Application for a non-material amendment following a grant of planning permission.
Town and Country Planning Act 1990

HOUSEHOLDER APPLICATION 3/2019/0384
PROPOSED NEW REPLACEMENT GARAGE AND GYM. ADDITIONAL
GUEST ACCOMMODATION - RESUBMISSION OF PLANNING
APPLICATION 3/2018/0675

3/2019/0384

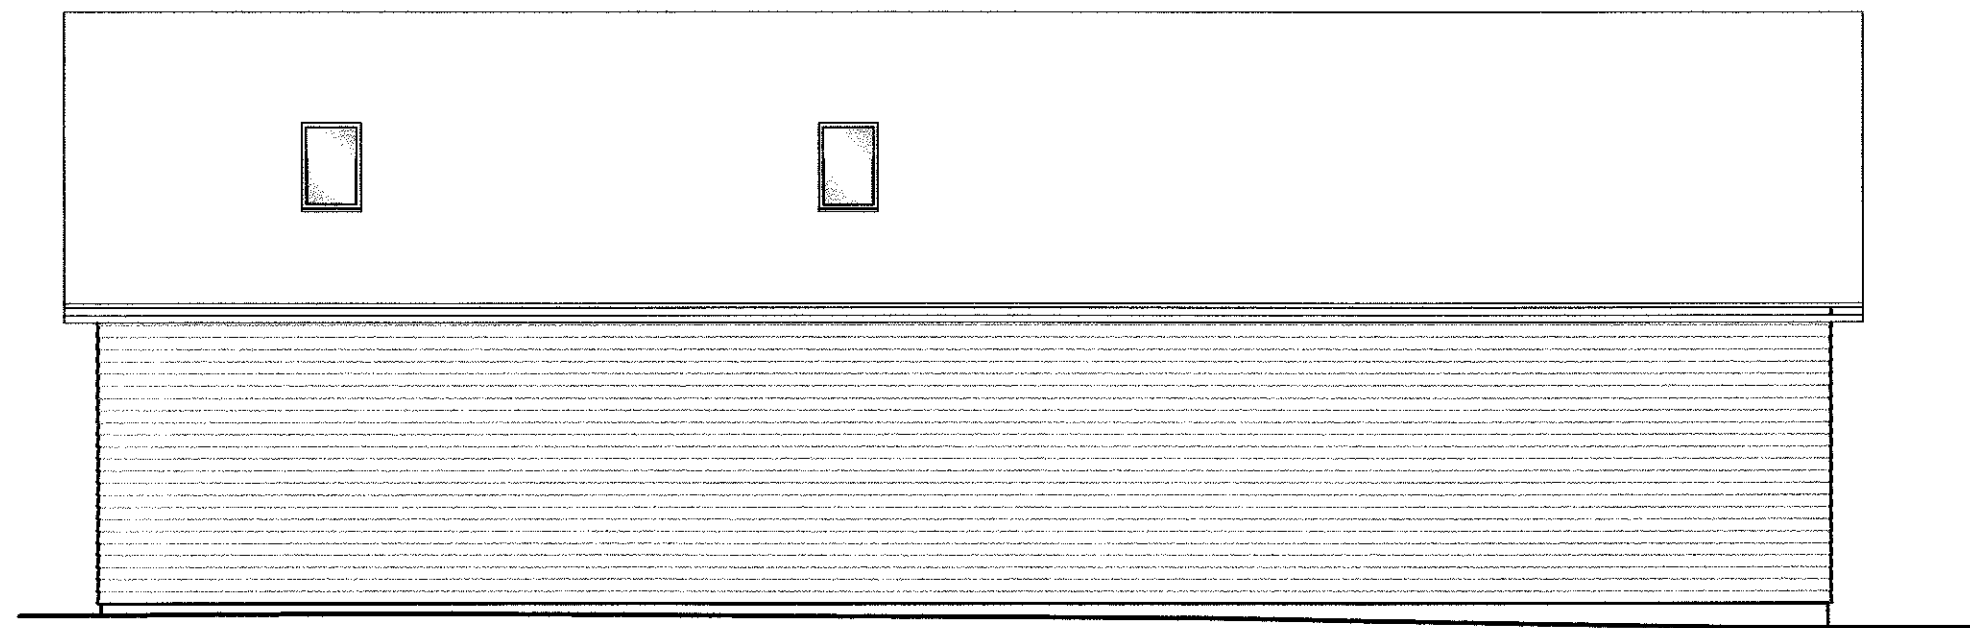
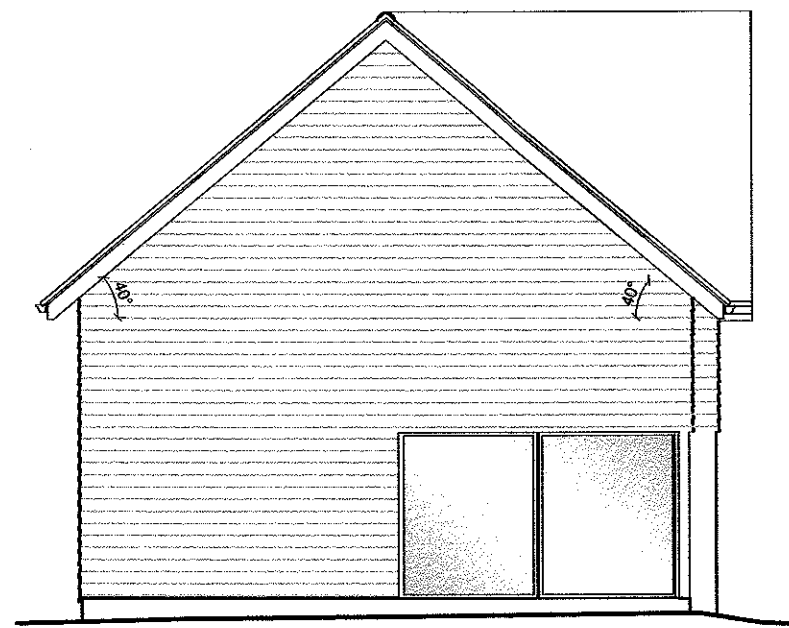
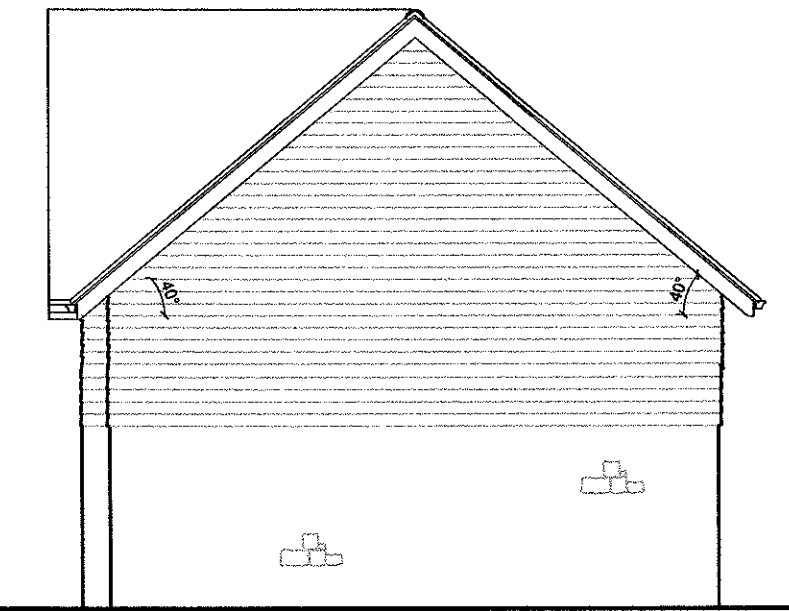
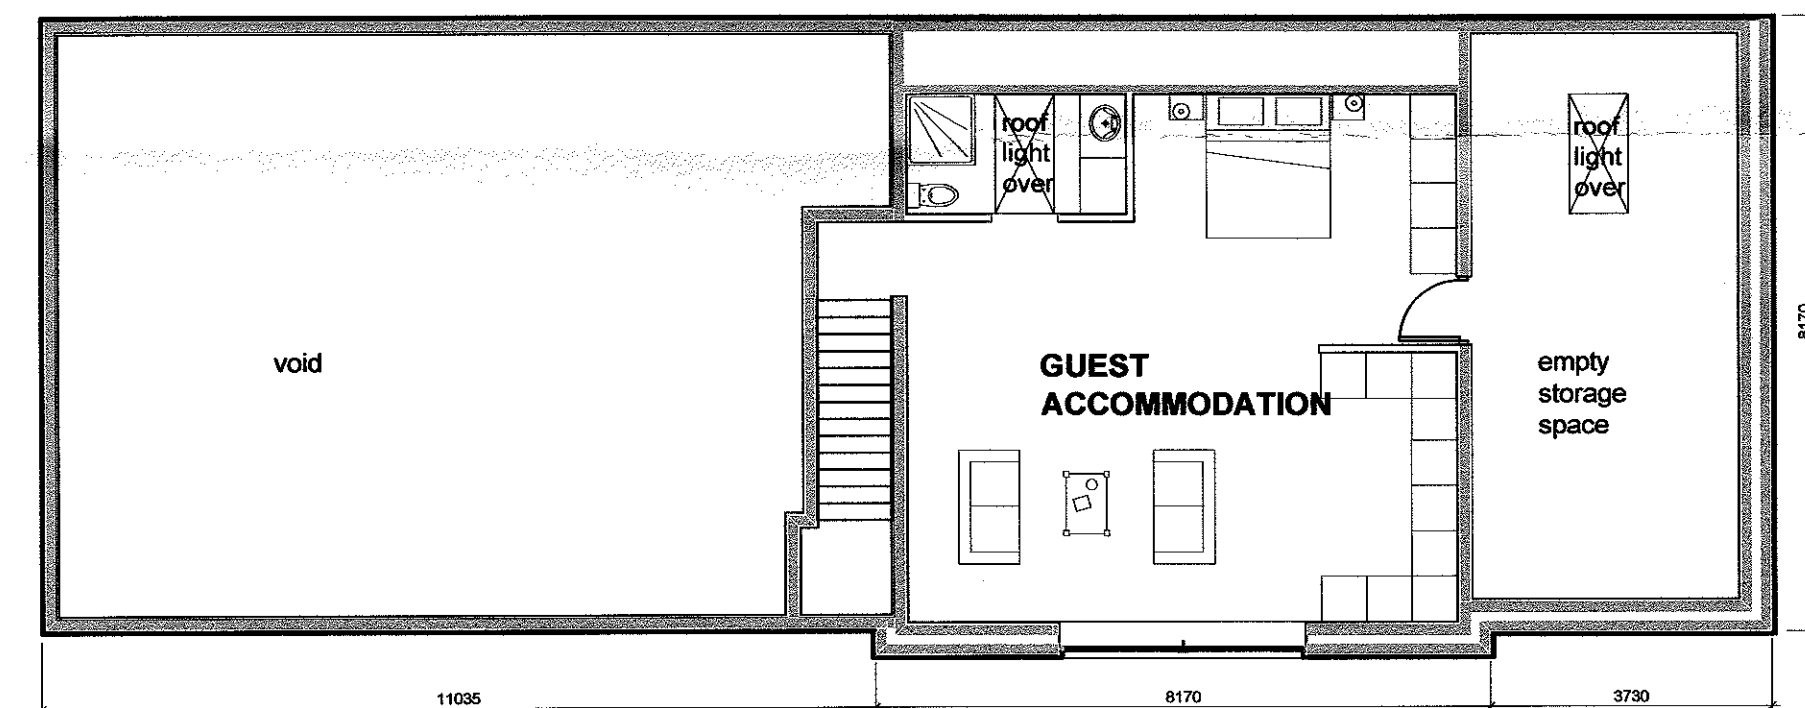
LARGER ROOFLIGHT OVER GUEST BATHROOM
ADDITIONAL ROOFLIGHT OVER STORAGE SPACE
BOTH ROOFLIGHTS MATCH THOSE TO MAIN DWELLING

ADDITIONAL ROOFLIGHT INSTALLED TO ADD LIGHT TO STORE ROOM
BOTH ROOFLIGHTS SAME SIZE AS THOSE TO MAIN DWELLING
